DELEGATED HOUSEHOLDER DECISION

Item No.	Report of the Head of Planning and Enforcement	
Address	47 BERKELEY ROAD HILLINGDON MIDDLESEX	
Development:	Conversion of roofspace to habitable use to include a rear dormer, 2 front rooflights and conversion of roof from hip to gable end	
LBH Ref Nos:	66315/APP/2017/625	
Drawing Nos:	Location Plan (1:1250) Block Plan (1:500) A/01 A/03 A/04 A/02 A/00 A/05	
Date Plans Received:	21/02/2017	Date(s) of Amendment(s):
Date Application Valid:	07/03/2017

PROPOSED SIDE ELEVATION
Scale : 1:100 @ A1

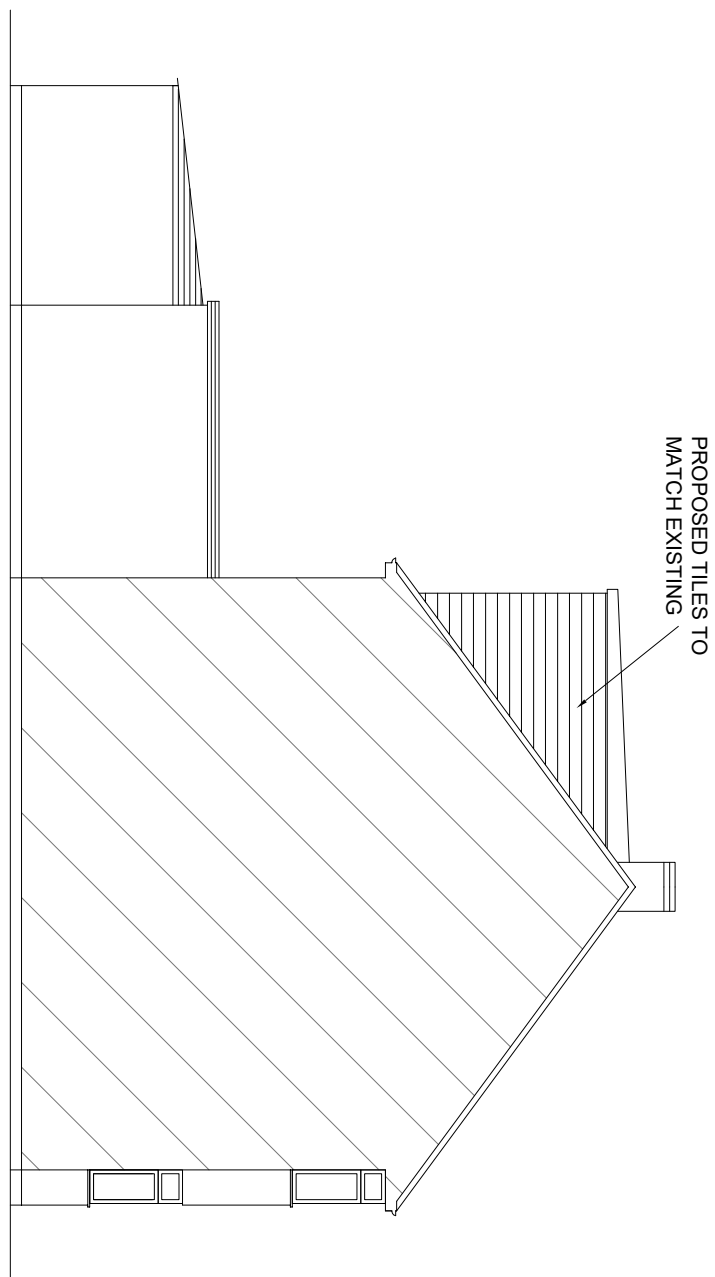
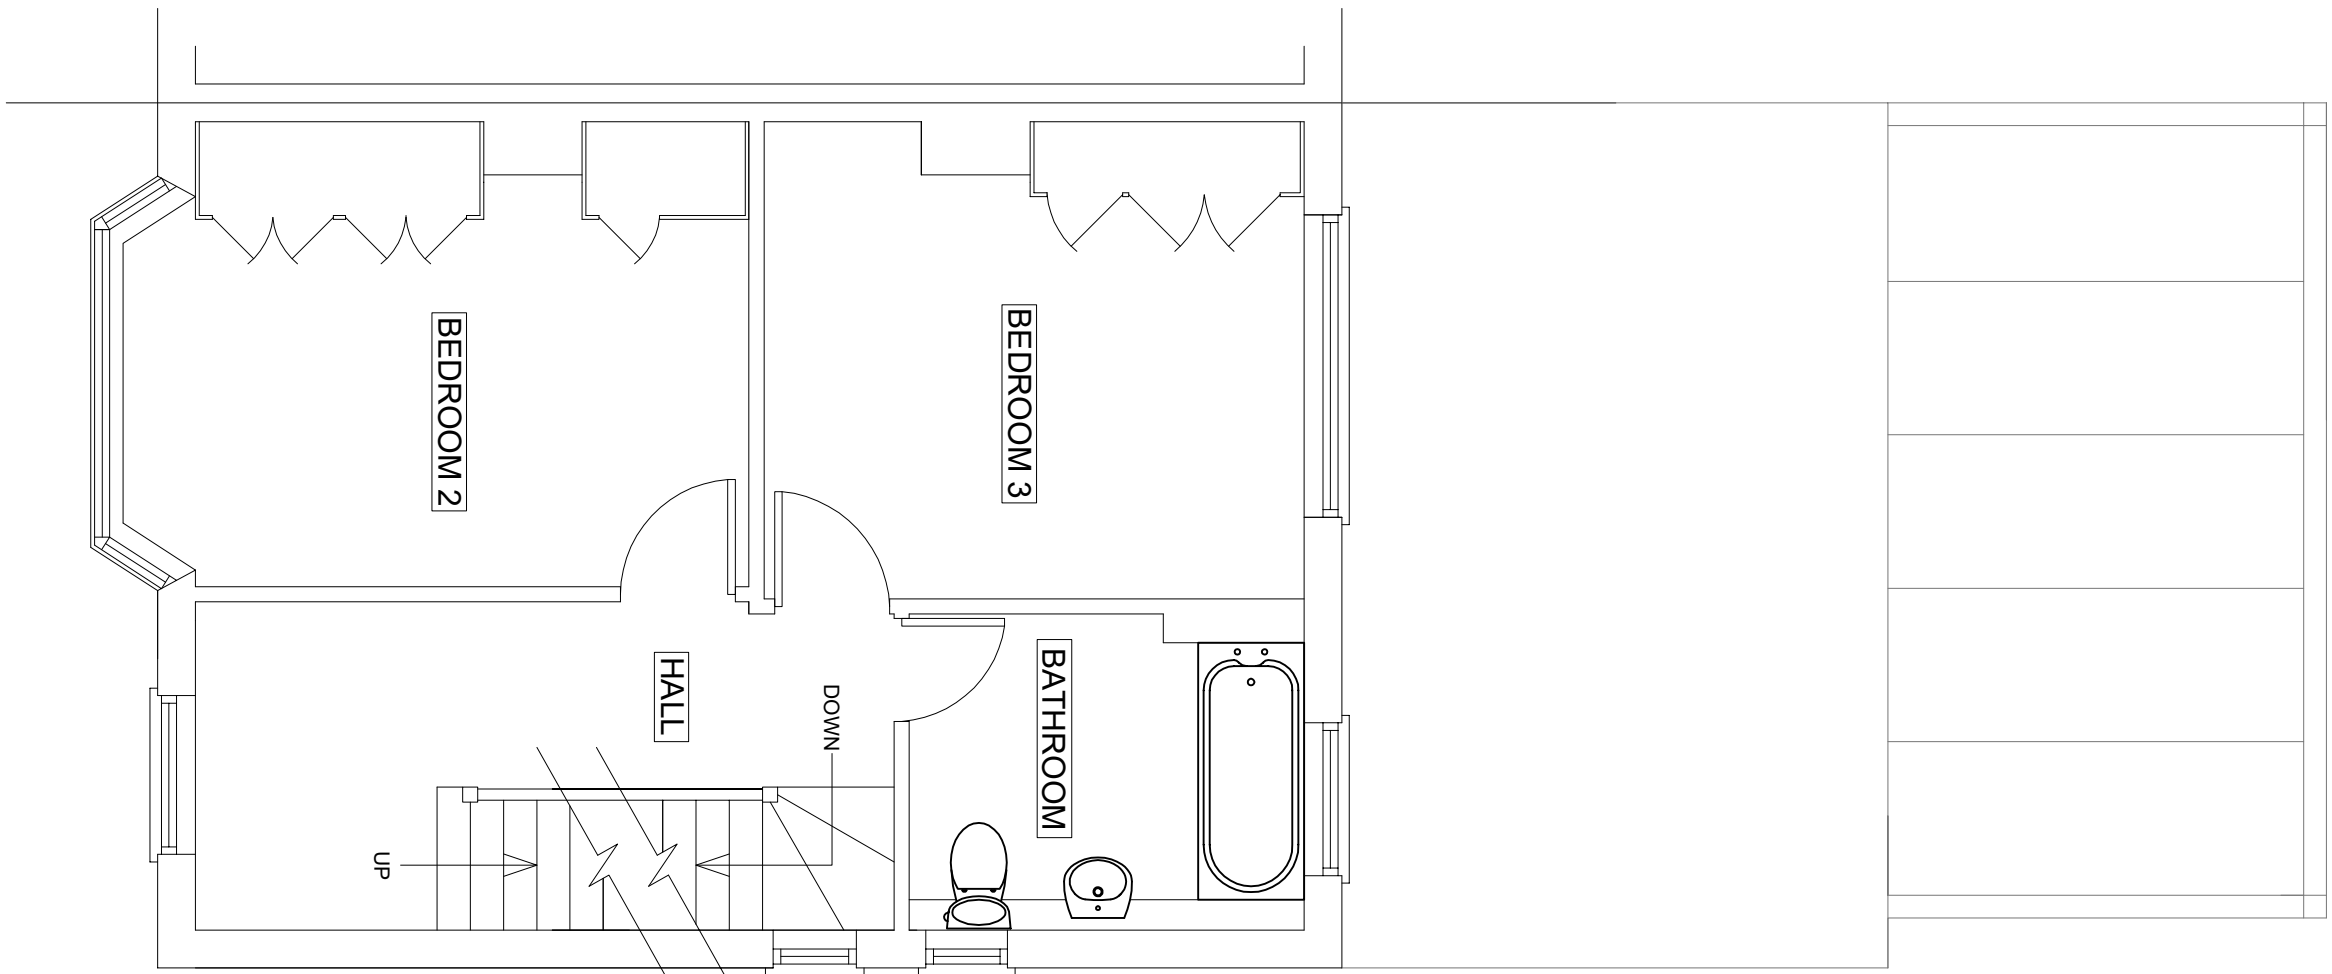
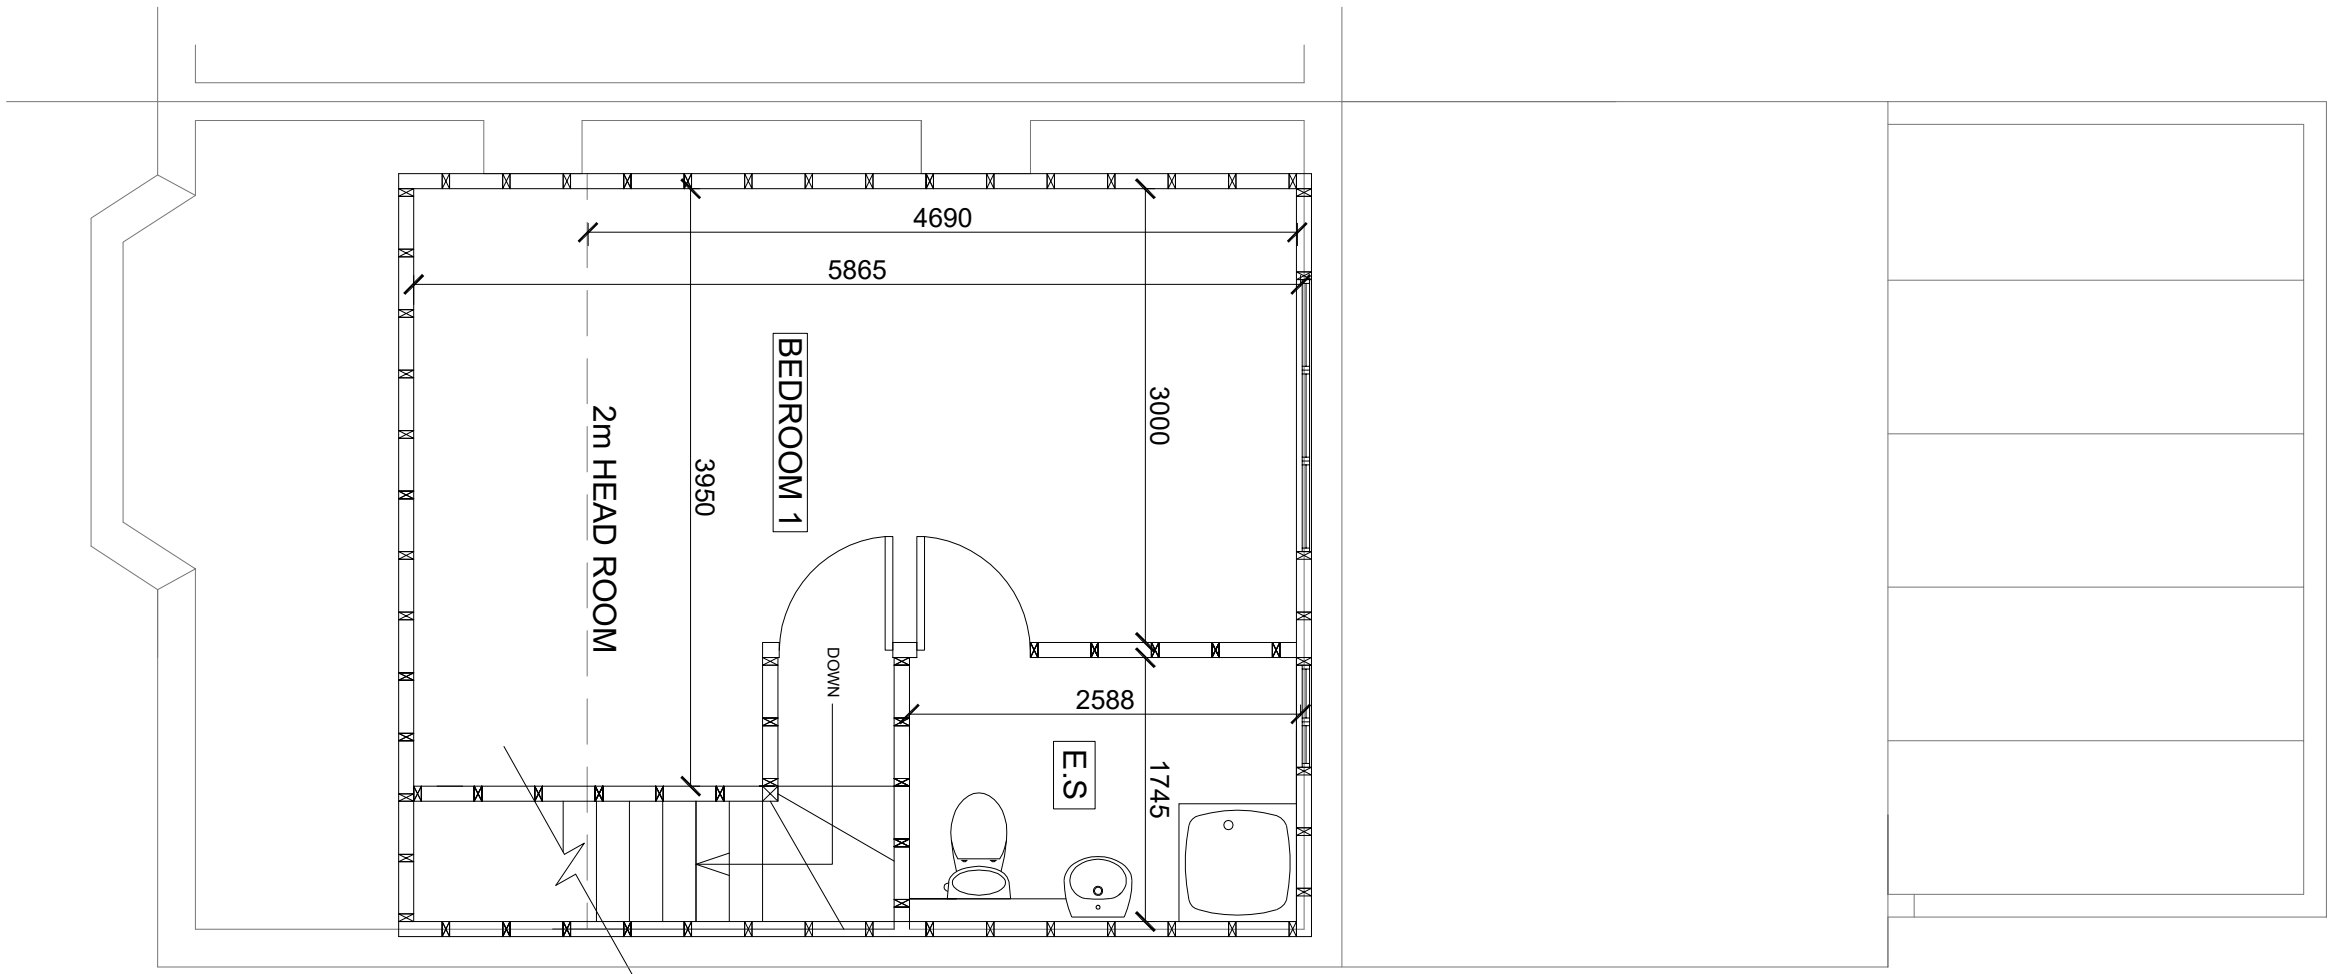
The HDAS guidance states that hip to gable end roof alterations would normally be refused. The gabled end would be at odds with the prevalent hipped roof form of dwellings within the vicinity and indeed the hipped roof end on the opposite end of this terrace. Furthermore the HDAS guidance requires alterations to the roof to appear as subservient features and appear secondary in the roof plane in which they are set. Windows should match in design and size and the dormers should be set in by at least 0.5 m on each side and set down 0.3 m from the ridge. The proposed rear dormer would dominate the rear roofslope and fail to respect the architectural integrity of the host building. The proposed extensions to the roof would have a negative impact upon the visual amenity of the site and the surrounding area in conflict with Policy BE1 of the Hillingdon Local Plan: Part One - Strategic Policies (November 2012), policies BE13, BE15 and BE19 of the Hillingdon

The roof alteration/extensions, by reason of the hip to gable end roof design and the size, scale, bulk and design of the rear dormer window would fail to harmonise with the architectural composition of the original dwelling, would be detrimental to the character, appearance and symmetry of the small terrace of houses of which it forms a part and to the visual amenities of the street scene and the surrounding area. Therefore the proposal would be contrary to Policy BE1 of the Hillingdon Local Plan: Part One - Strategic Policies (November 2012), Policies BE13, BE15 and BE19 of the Hillingdon Local Plan: Part Two - Unitary Development Plan Saved Policies (November 2012) and the adopted Supplementary Planning Document HDAS: Residential Extensions.
